DEVELOPMENT FACILITATION TEAM

Planning - Case Comments

Project Number: PR-2020-004448

Project Name: Kairos Power, 5201 Hawking Dr. SE

LANDSCAPE
SITE PLAN
CALCS
LP-101

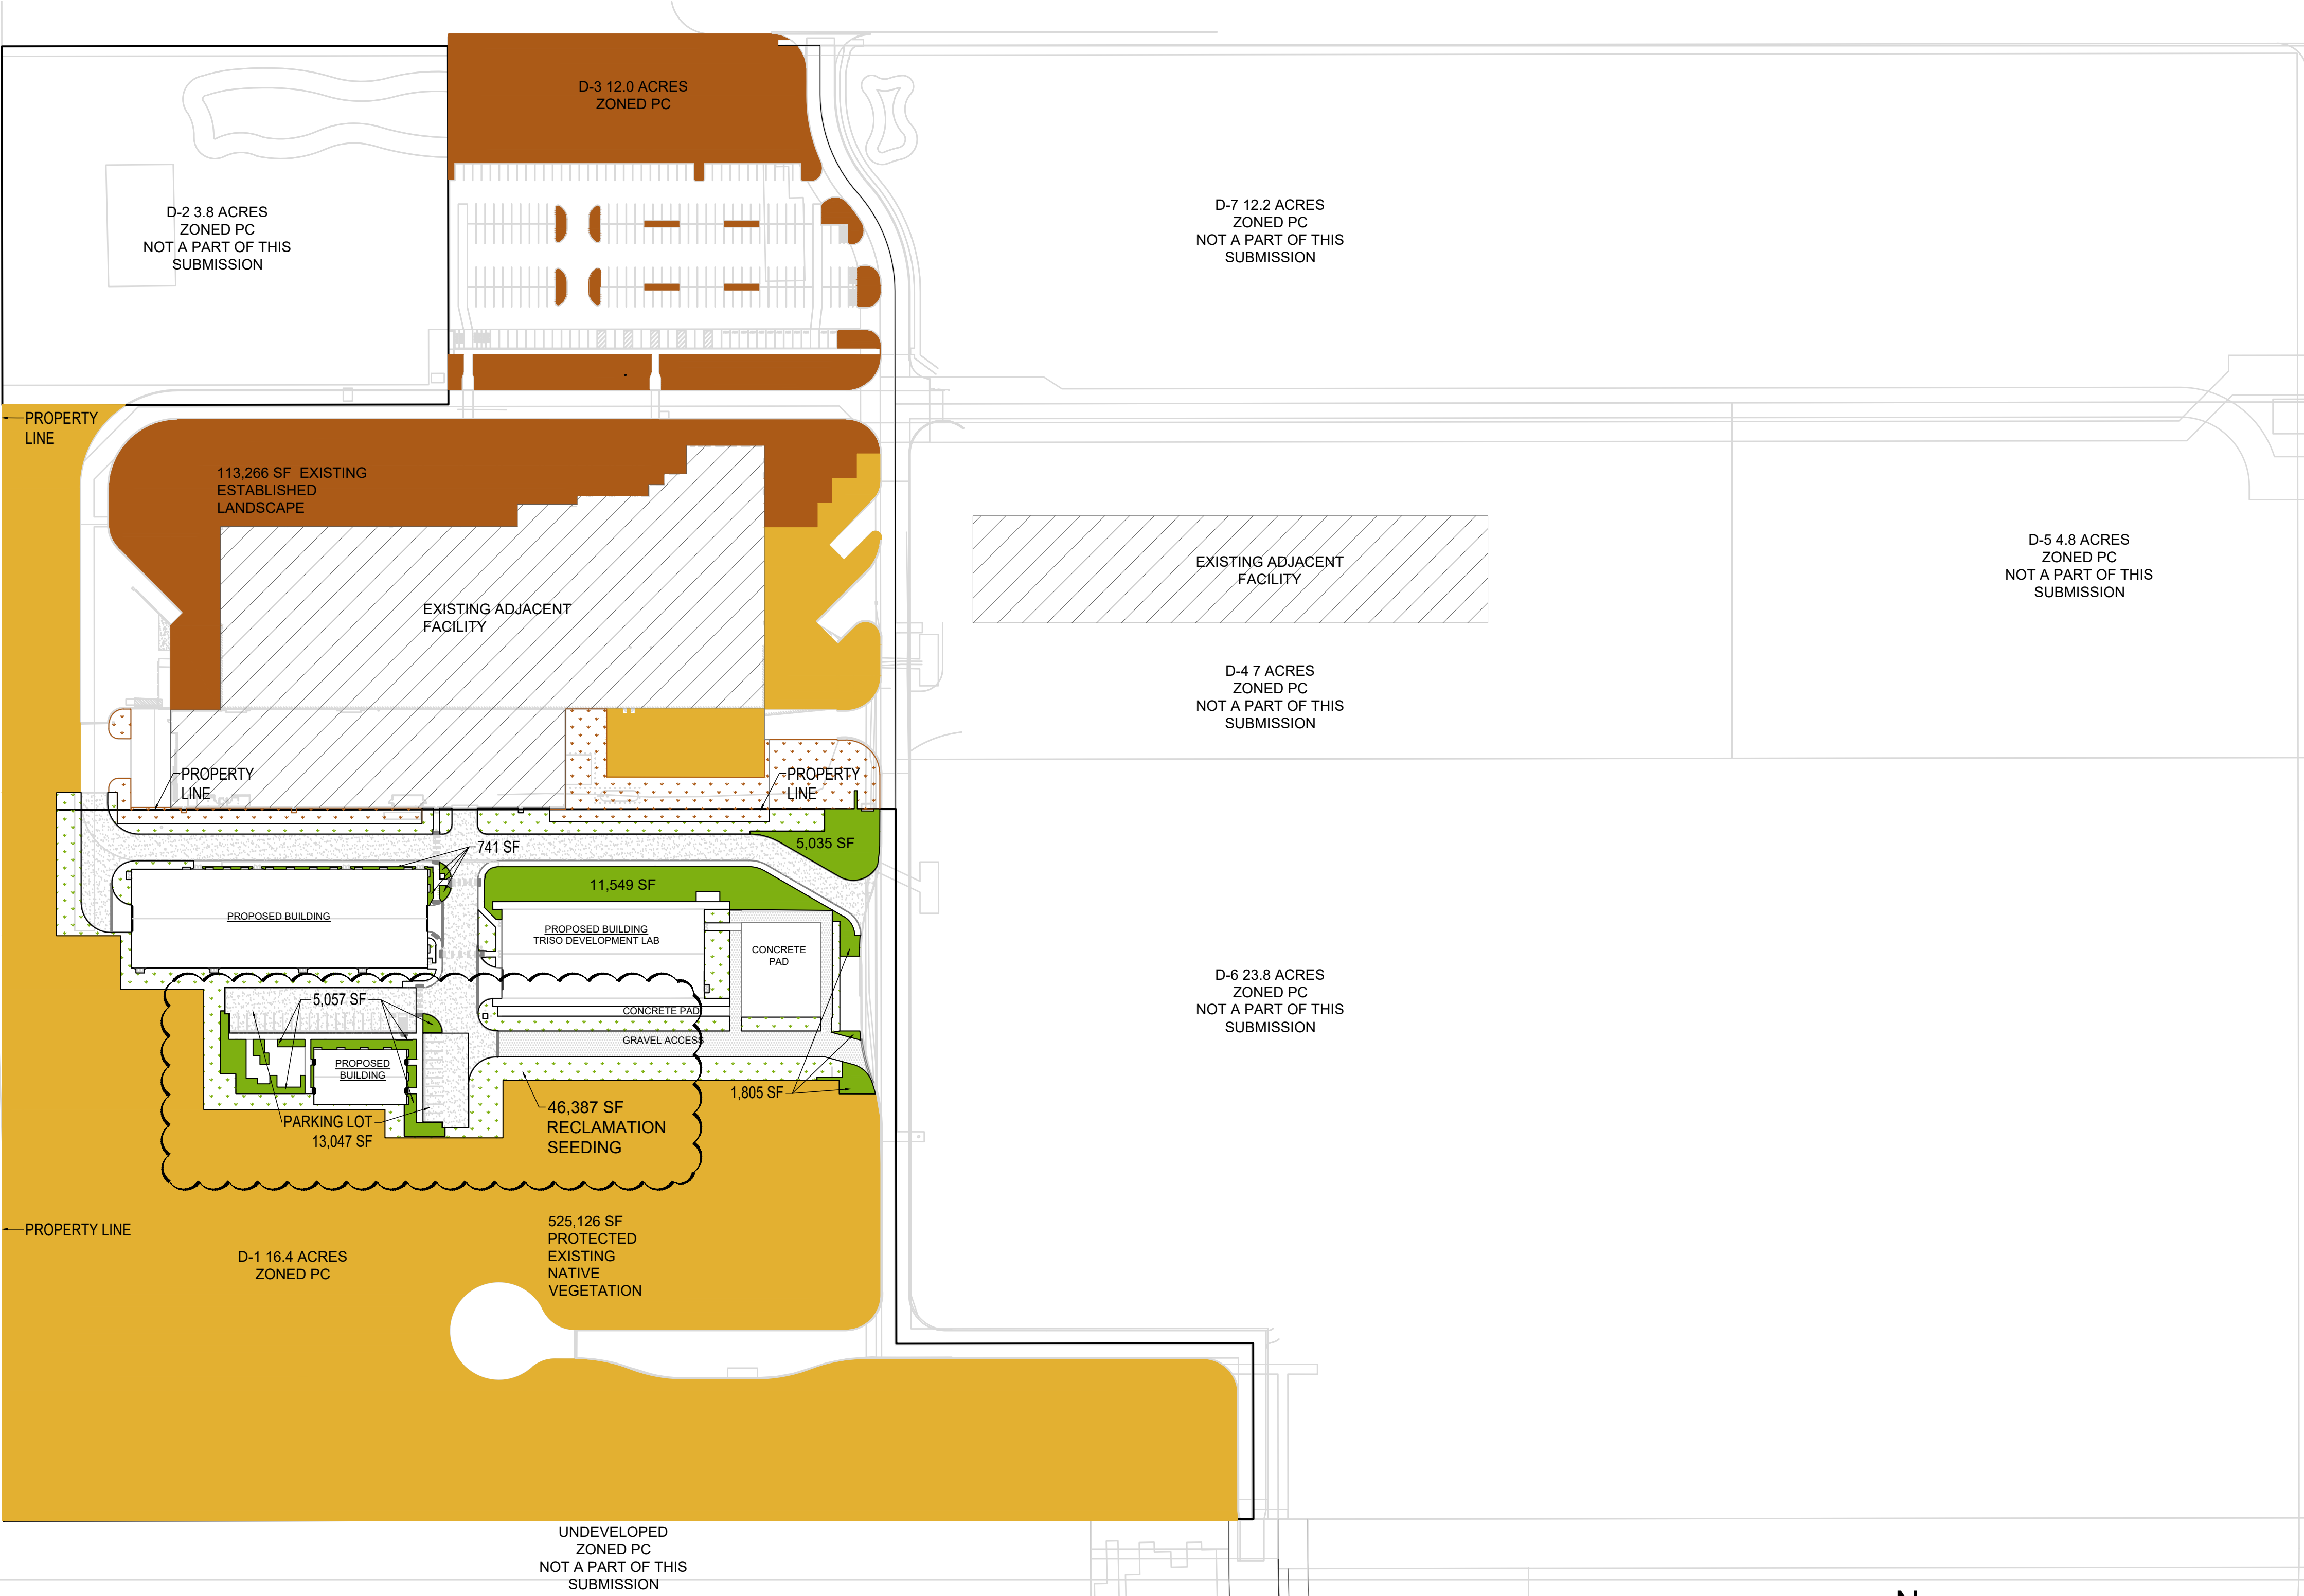
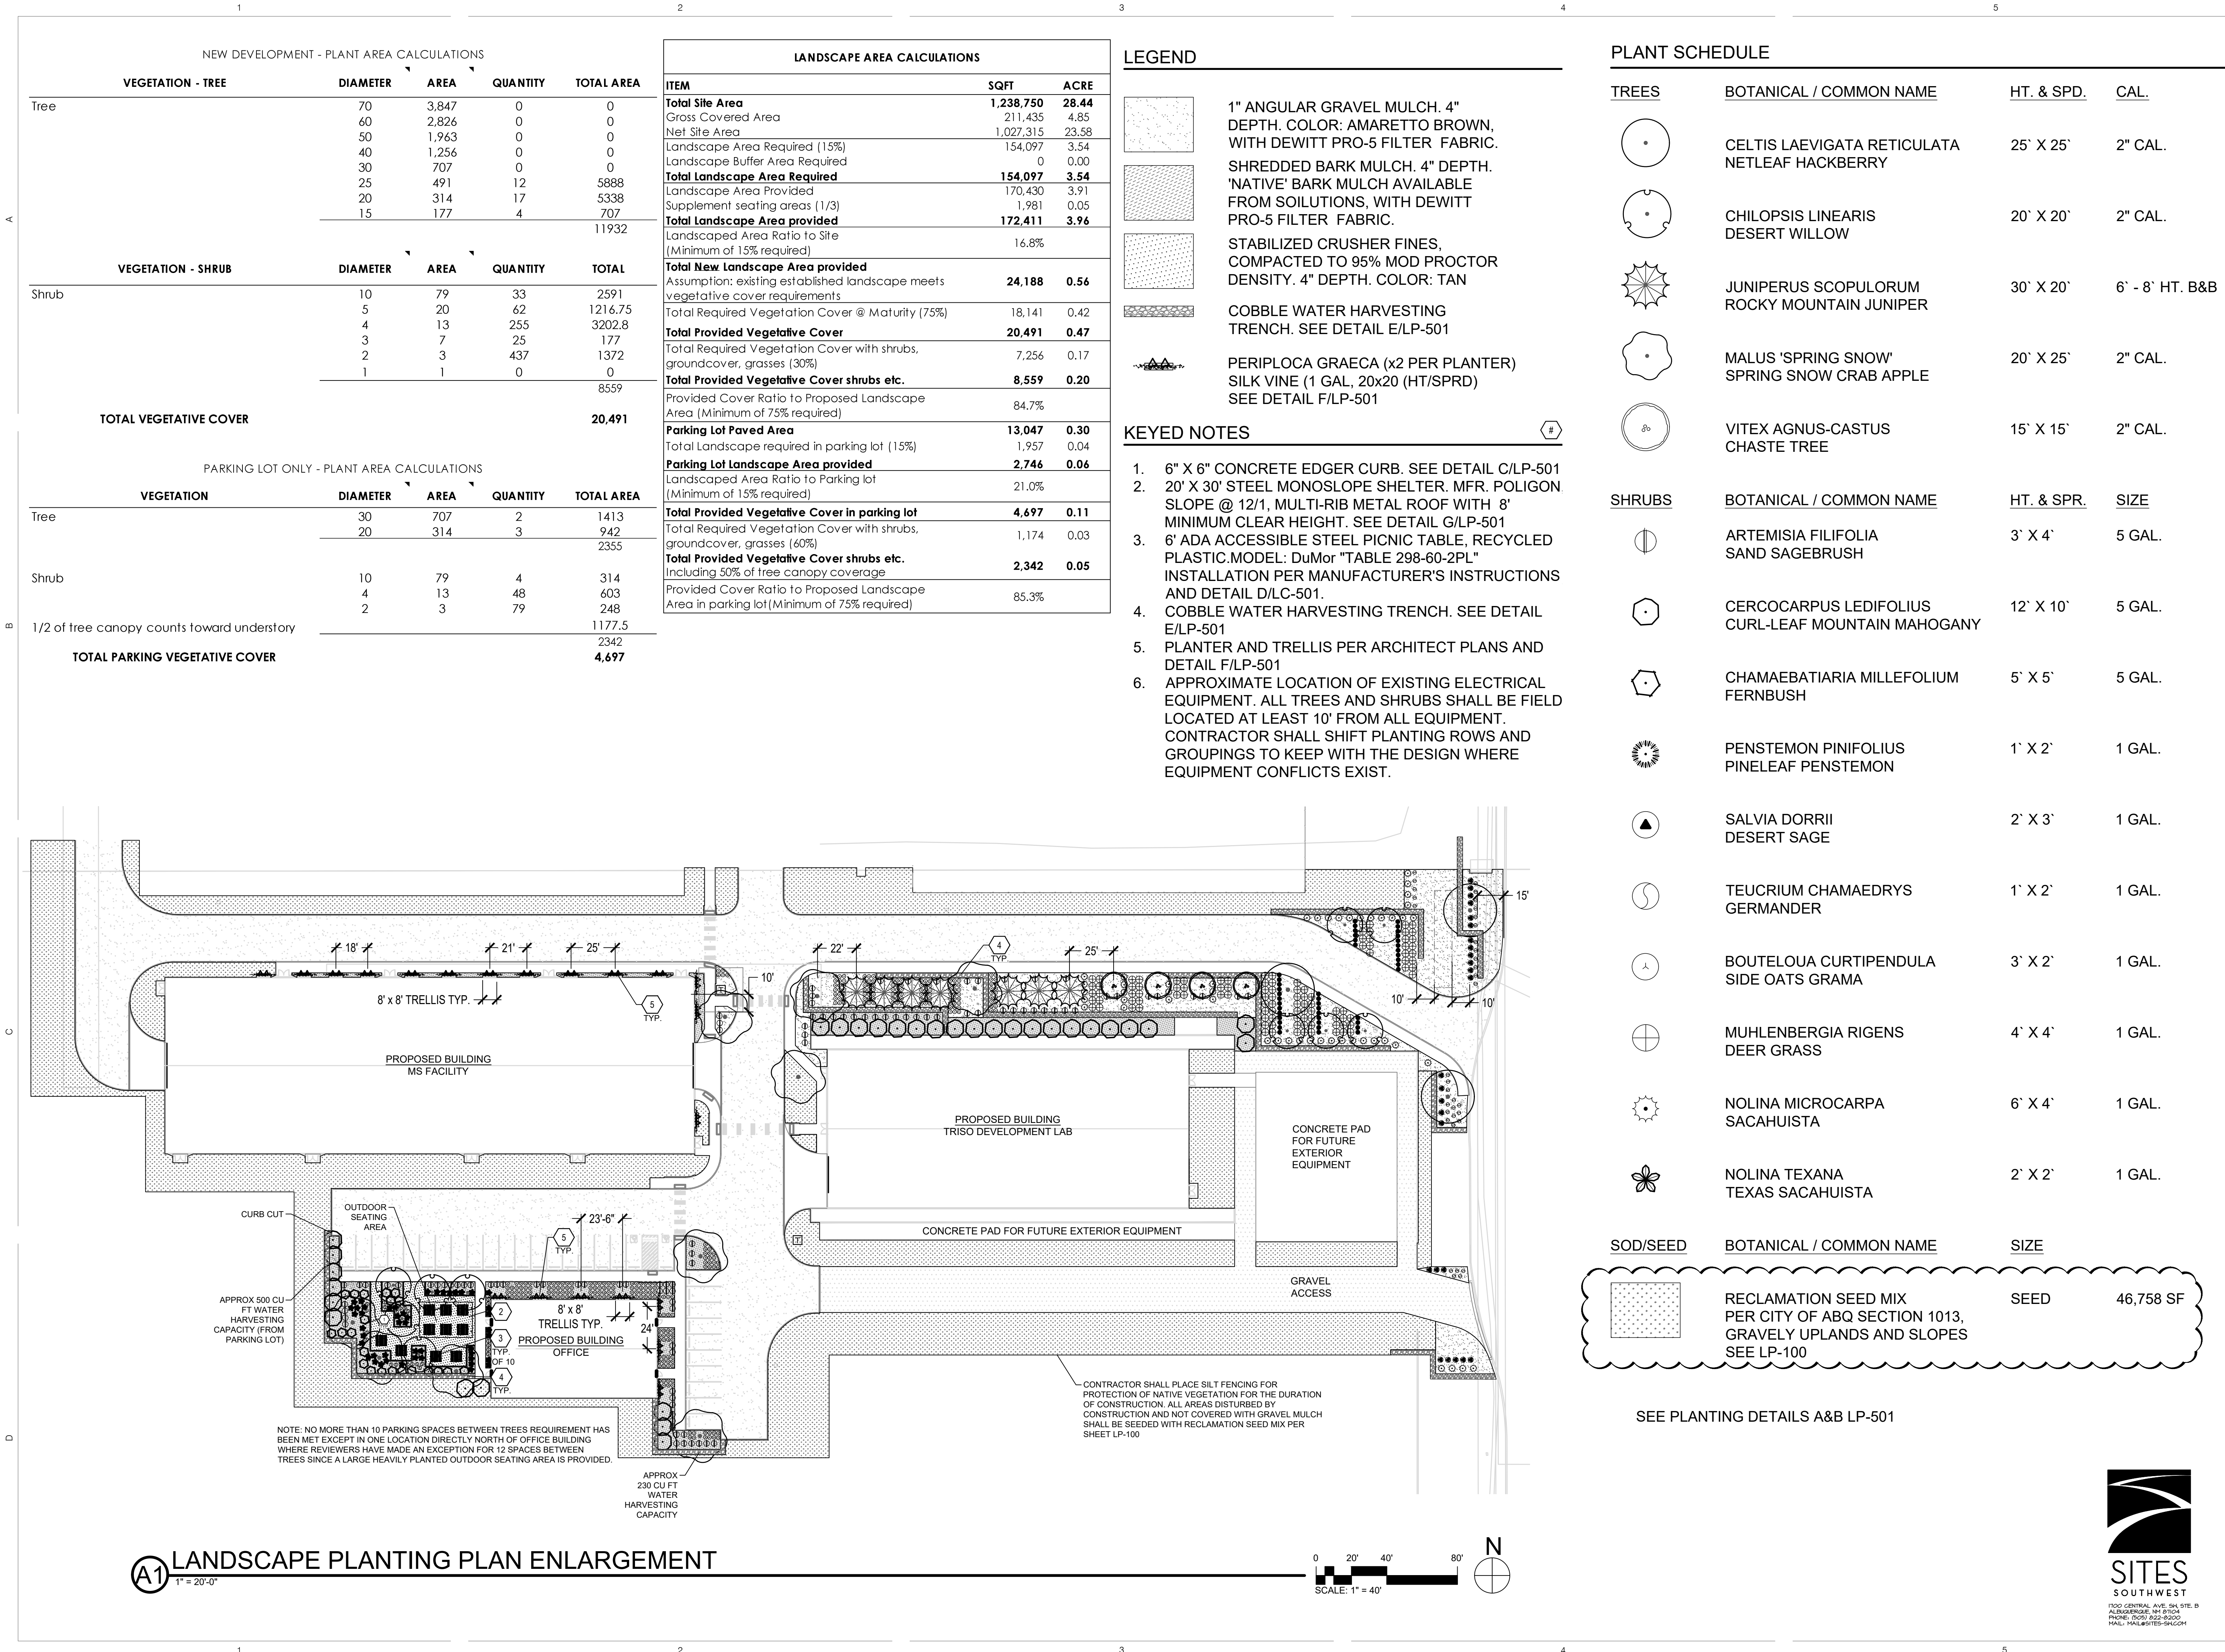
- The MdS Level B Plan requires “water harvesting areas for surface runoff shall be provided in parking lots.” (See 2.2.2(g)(v), p. 18.) Please confirm compliance for the gravel parking areas on LP-102. Please also note compliance with MdS Level B Plan Section 2.2.4 Site Design Standards, as applicable.

- Sapindus Drummondi is not on the City of Albuquerque official trees list.
- Reference note in Planting Legend “Reclamation seed mix, see LP-100”.
-- Identify species in Reclamation Seed Mix. (Recommended you use a seed mix per Section 1013.)

- IDO 5-6-D Required Street Trees.
 - IDO 5-6-F Parking Lot Interior. Confirm compliance and calculations that 10% landscaped of parking lot interior is landscaped.
--Provide parking calculations per IDO 5-6(F)(2)(c) Tree Requirements. Clarify the following:
